AB/55/20/PL

5 The Old Slipway River Road Arundel BN18 9EY

New second floor Juliet balcony.

**Second Floor Plan + Elevations**  
*as Proposed*

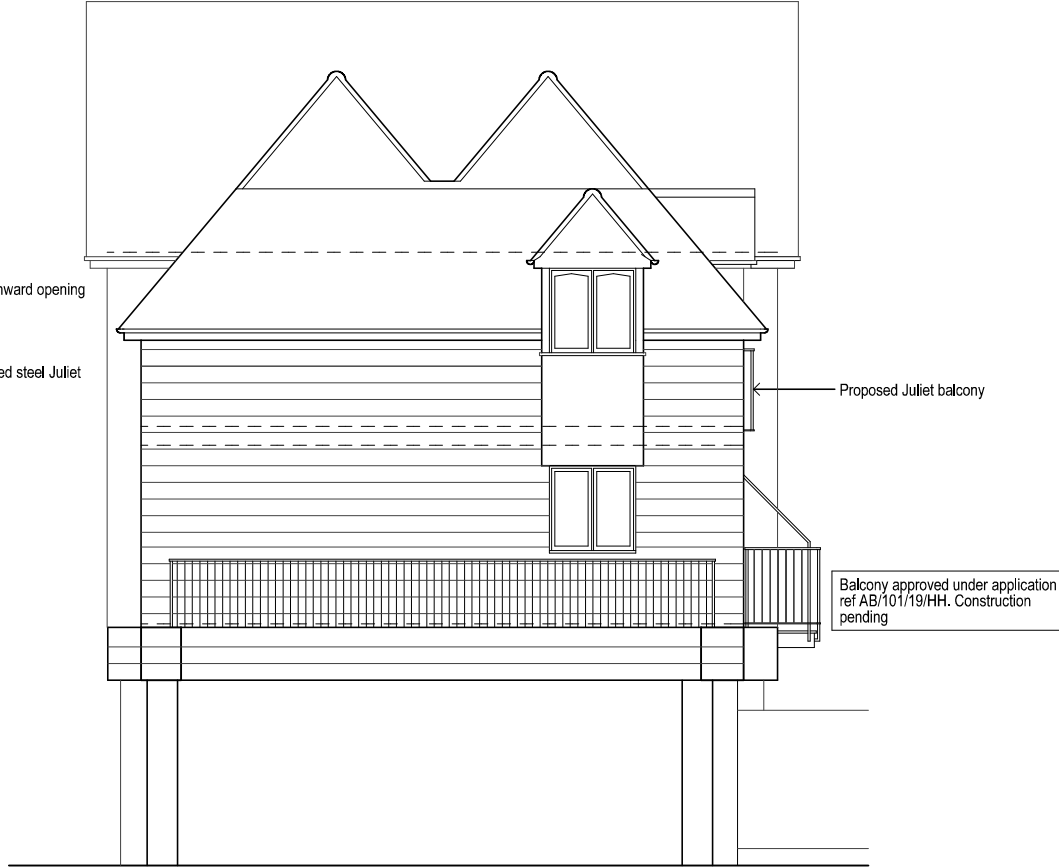
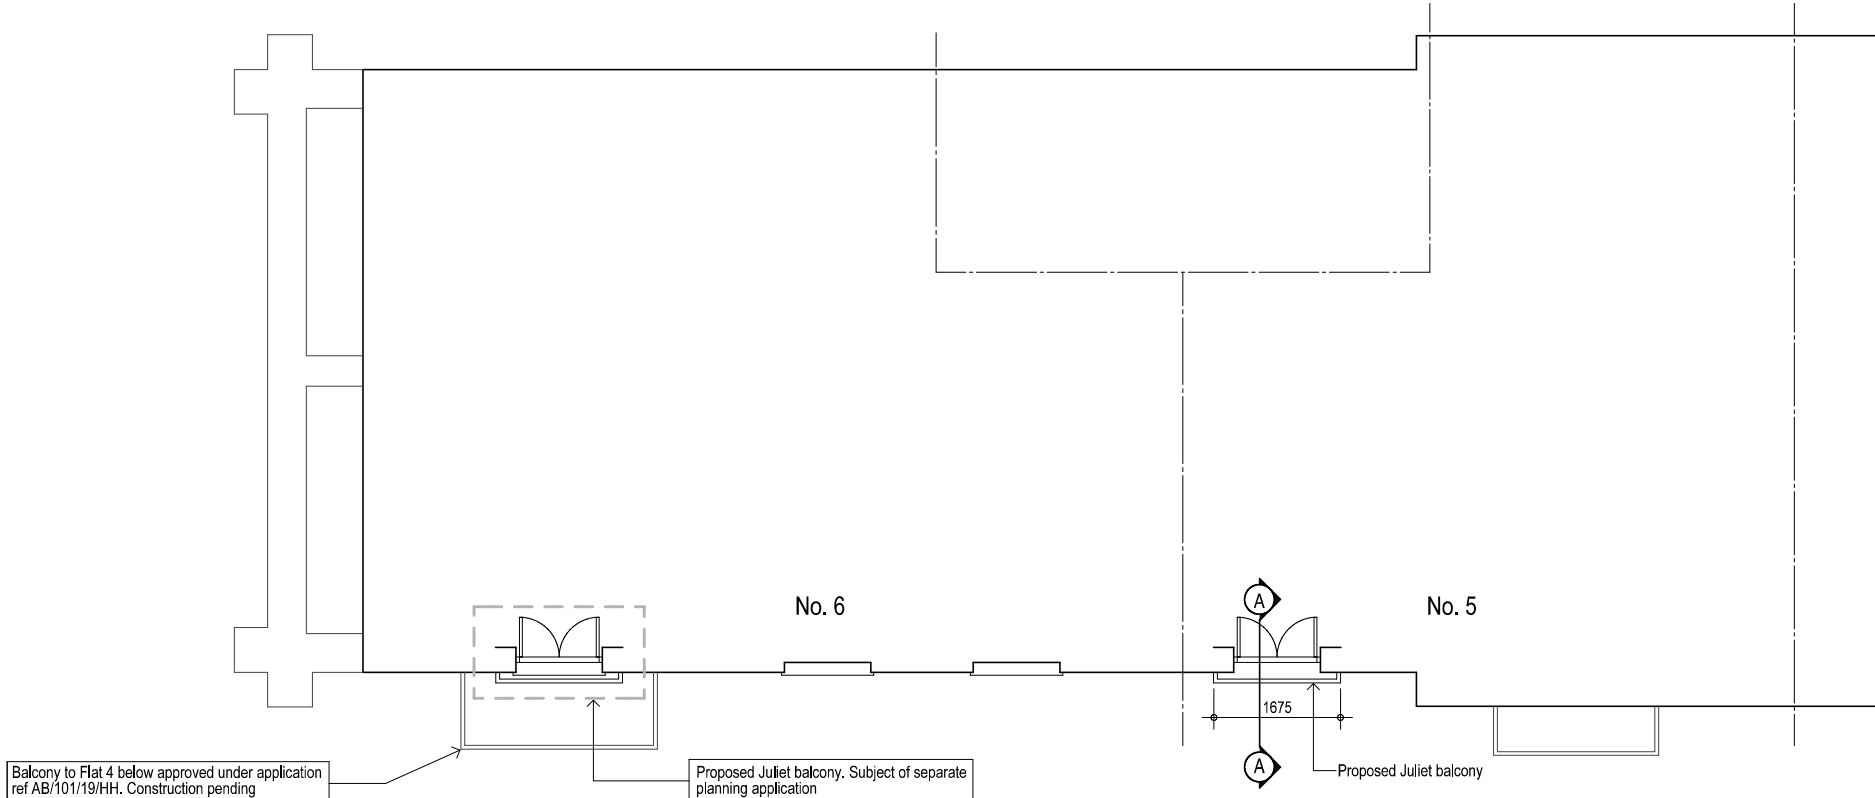
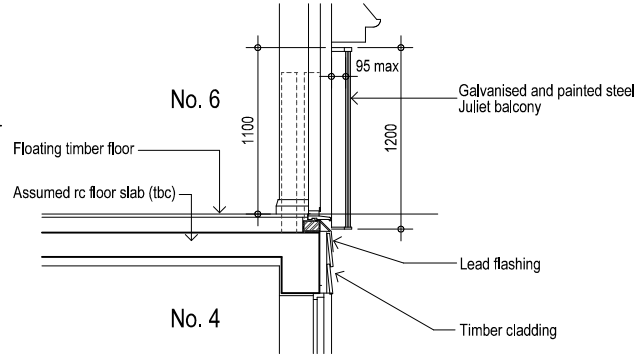
The proposal is to remove an existing south facing window and install inward opening French doors. A galvanised and painted steel Juliet balcony will be fixed to the face of the building.

It is considered that the proposal is of a scale which will not harm the appearance of the building or the character of the local area. The new French Window should match the existing joinery in terms of appearance, and colour. Likewise, the balcony should also be the same colour as those already present.

It is noted that there is also a separate application for the same proposal in another apartment within the building. When considered together the proposals will maintain the symmetry of the façade, and it would be preferable if they were implemented at the same time.
